## Department of Primary Industries

### **Dubbo Zirconia Project (SSD-5251) Response to exhibition of Environmental Impact Statement**

### Dubbo Zirconia Project (SSD-5251) Response to exhibition of EIS

Figure 2.13
CROSS-SECTIONAL DESIGN
OF THE LIQUID RESIDUE STORAGE FACILITY

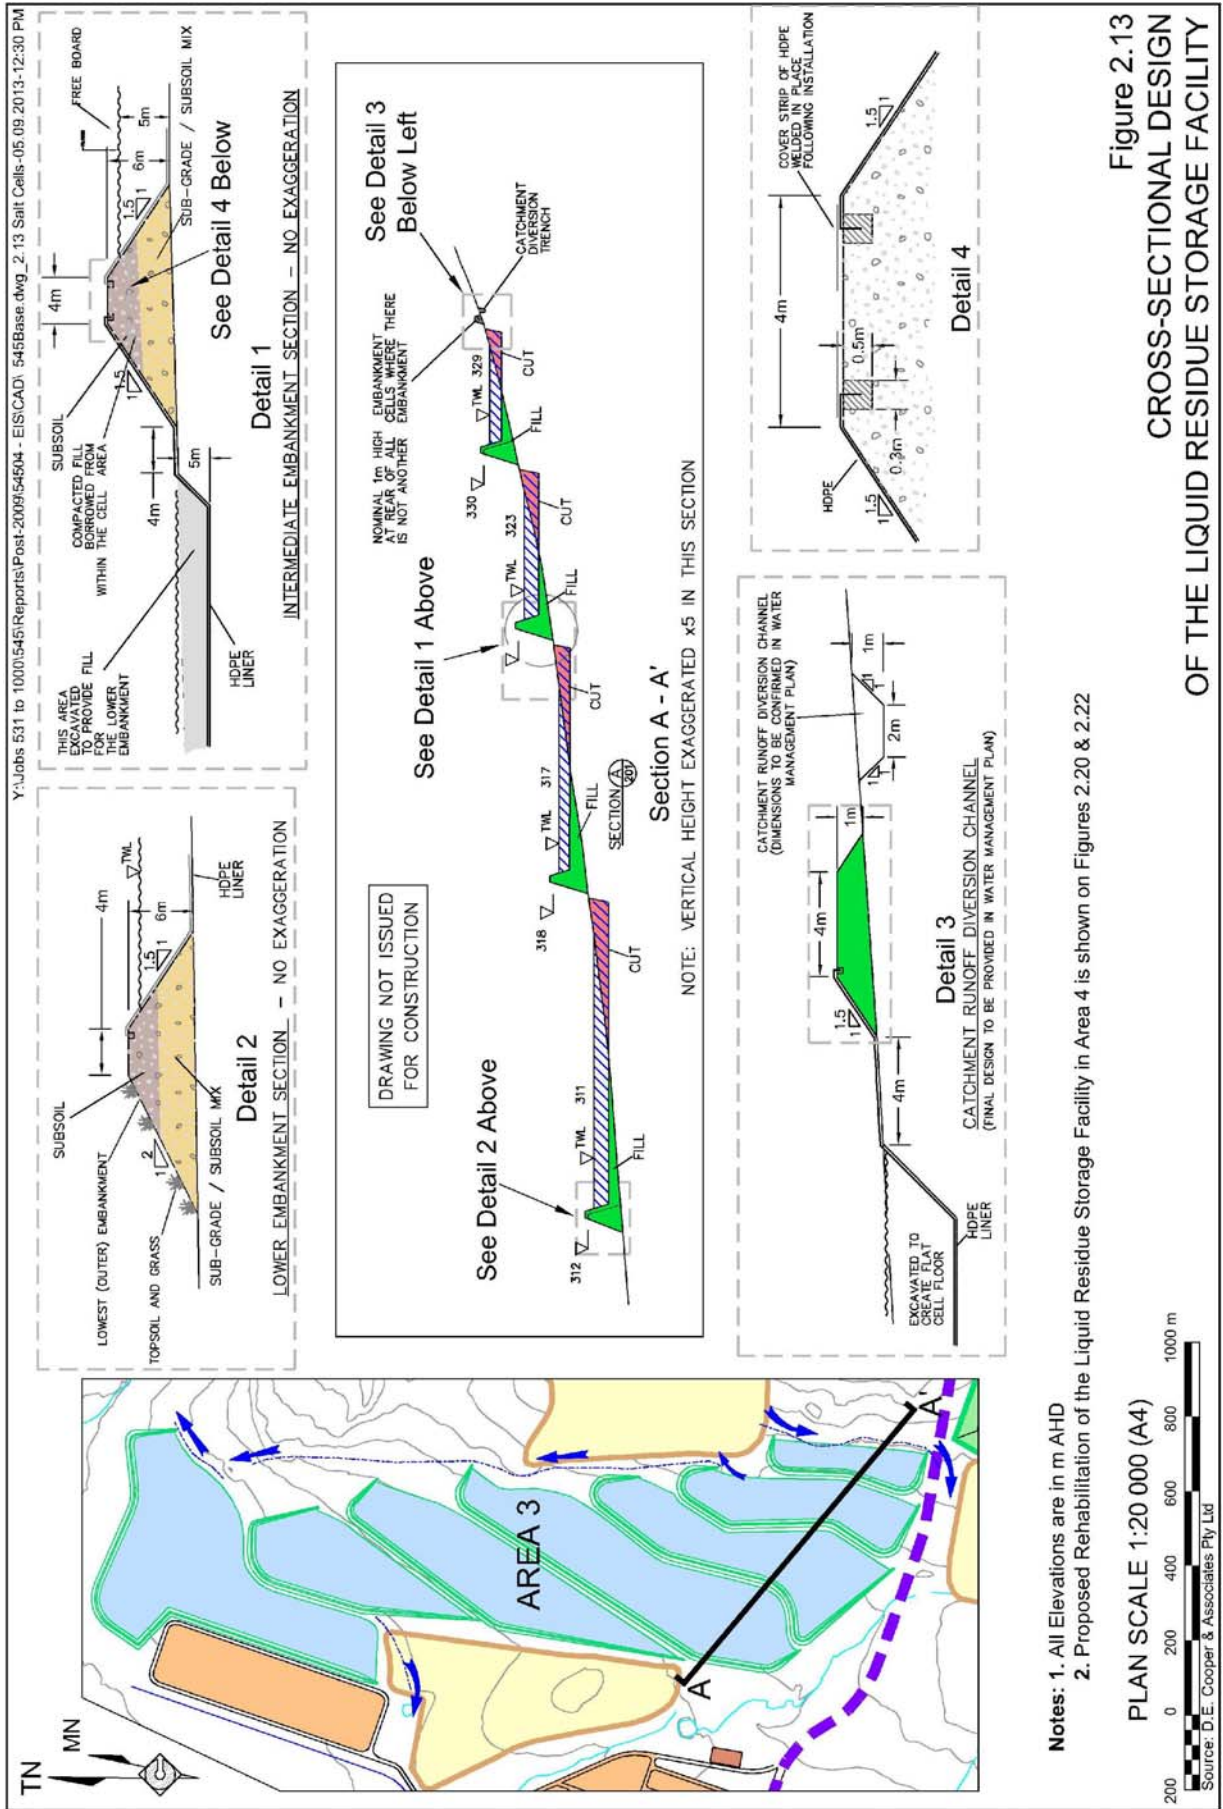
- (ii) The significantly high salinity water to be stored in the Liquid Residue Storage Facility represents a risk to local groundwater and surface water systems. The ability to ensure adequate initial investigations and the implementation of mitigating measures and contingency plans is critical.

- Section 4.5.5.7 (main EIS) indicates the flood assessment identified the potential for parts of the processing plant to be inundated in the downstream section of Watercourse C. Proposed embankments to mitigate the floods are predicted to increase the flow velocity by 0.4-0.5 m/s however this will be below 1.6 m/s which is stated as an accepted velocity for vegetated channels. The proposed mitigating measures to enhance stability on the bottom embankment of the Liquid Residue Storage Facility (LRSF) are supported.

- The significantly high salinity water to be stored in the LRSF represents a risk to local groundwater and surface water systems. The ability to ensure adequate initial investigations and the implementation of mitigating measures and contingency plans is critical.

- Section 6.2.3 of the Groundwater Assessment indicates a decision on whether the Salt Encapsulation Cells (SEC) will remain on-site or be removed is yet to be made. It is recommended this be confirmed prior to determination of the project to ensure adequate consideration of mitigating and monitoring requirements. The proposal in Section 2.9.4.4 of the main EIS to pump any leakage from the SEC's post closure to the LRSF may not be possible if the liner of the LRSF has been removed. It is therefore recommended this be given further consideration.

Figure 7: Macquarie River Water Pipeline

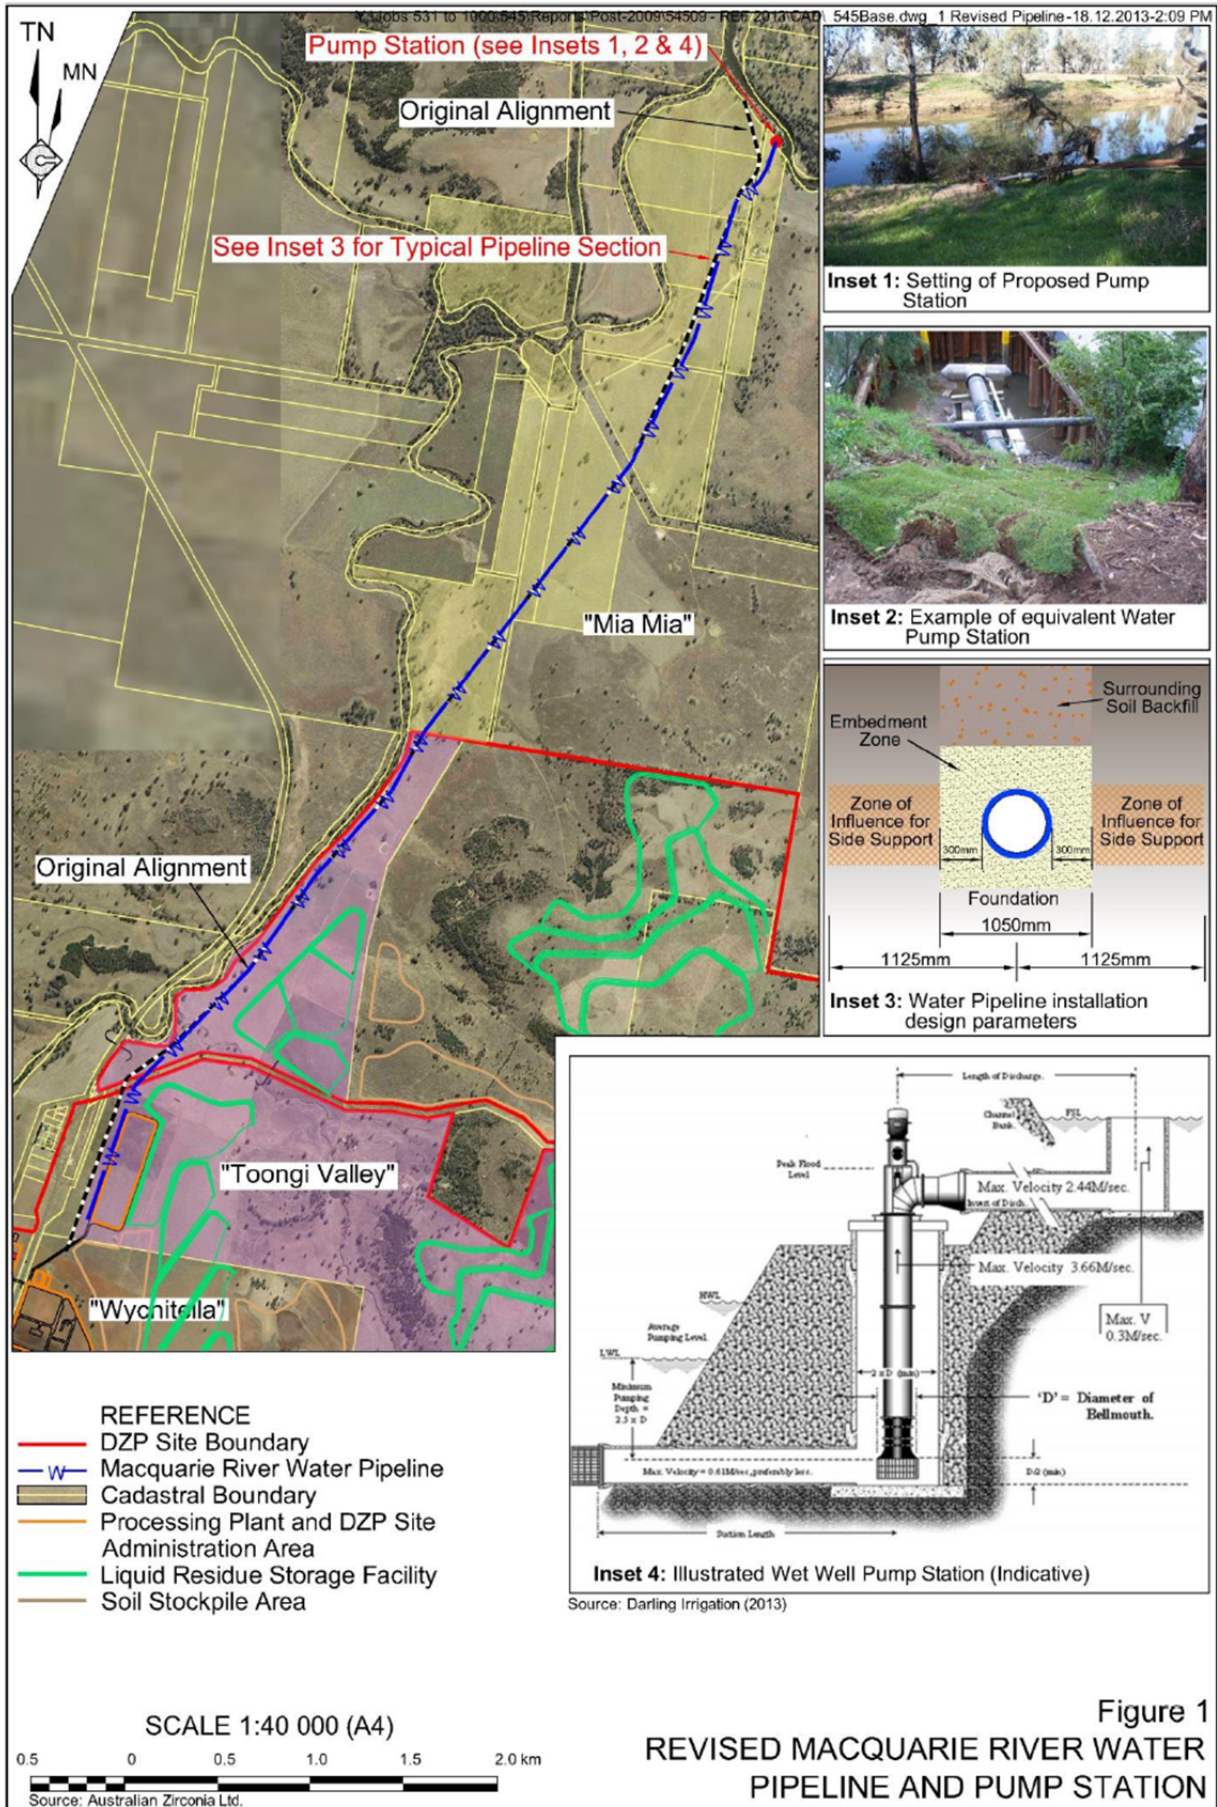
- The proposed water pipeline and natural gas pipeline will cross several minor drainage lines. In addition, the water extraction point on the Macquarie River will require disturbance to the river bed and banks. The NSW Office of Water recommends works within 40 metres of waterfront land be carried out in accordance with the CAA guidelines.

2. Detailed designs of the water extraction pump and proposed pump screens on the intake structure at the Macquarie River are to be provided to *Fisheries NSW* for review and comment, to ensure that *Fisheries NSW* is satisfied that entrainment and entrapment of juvenile fish and larvae is minimised. Details of the operation and management of the pump and intake structure should also be provided to *Fisheries NSW*, in particular the "start up" operations and water intake velocity.
